KITTITAS COUNTY

DEPARTMENT OF PUBLIC WORKS

MEMORANDUM

TO: Community Development Services
FROM: Kittitas County Public Works Plan Review Team
DATE: February 17, 2022
SUBJECT: SE-22-00002 Cape

Parcel #19162 Driveway Improvement Extents

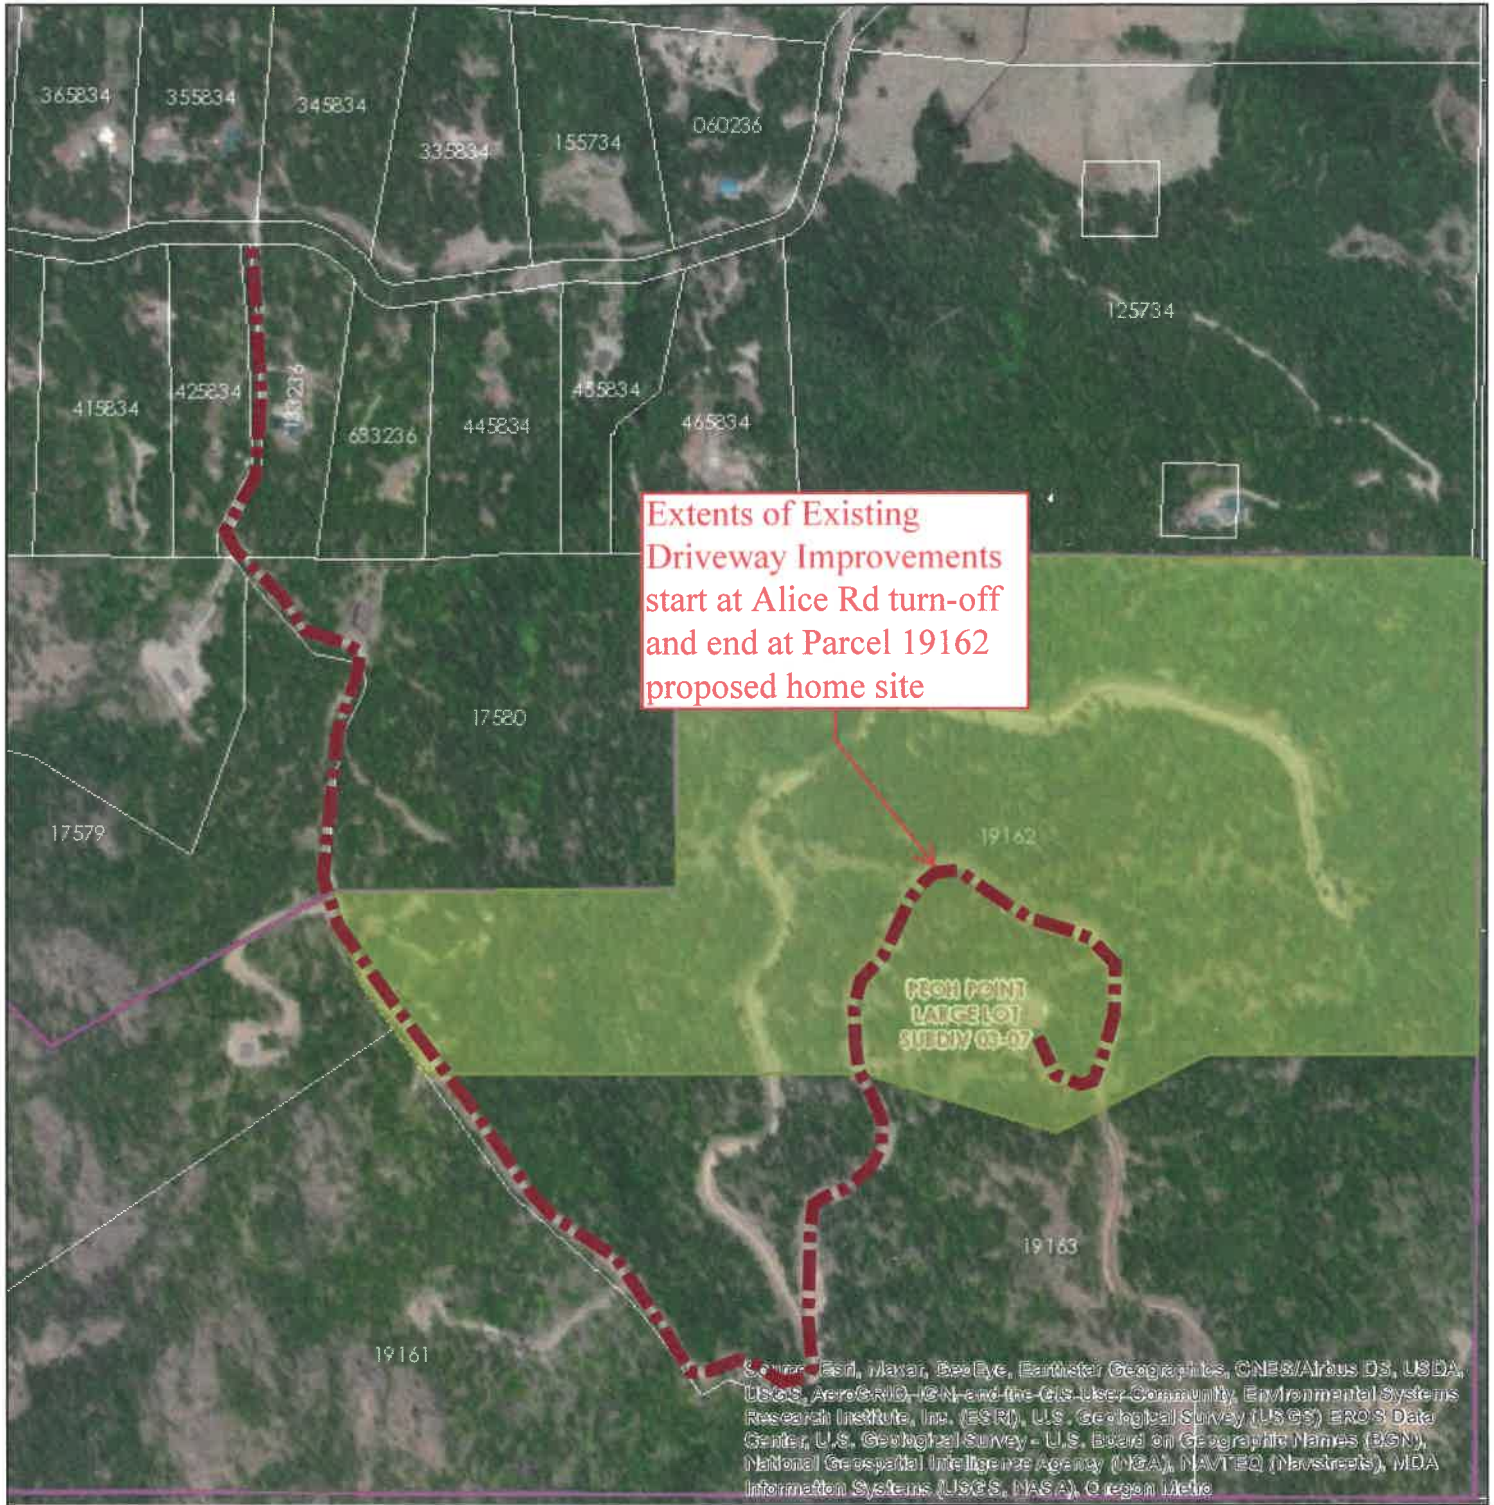
- Please be aware that standard maximum driveway grade is 10%. Additional mitigation is required for grades exceeding 10%. See Kittitas County Code 12.04.080 Table 4-4B for mitigation options. A project of this length would be able to achieve up to a 15% grade with additional mitigation. Grades exceeding 15% would require a variance.

- This project will require engineered grading and stormwater plans. Please submit a grading permit to Public Works. The grading permit must be reviewed and issued prior to any grading. The grading permit cannot be issued until the SEPA application is approved.

2. Any driveway improvements constructed beyond the current driveway limits OR outside the existing sixty-foot (60') wide easement will need approval from the property owner of record.
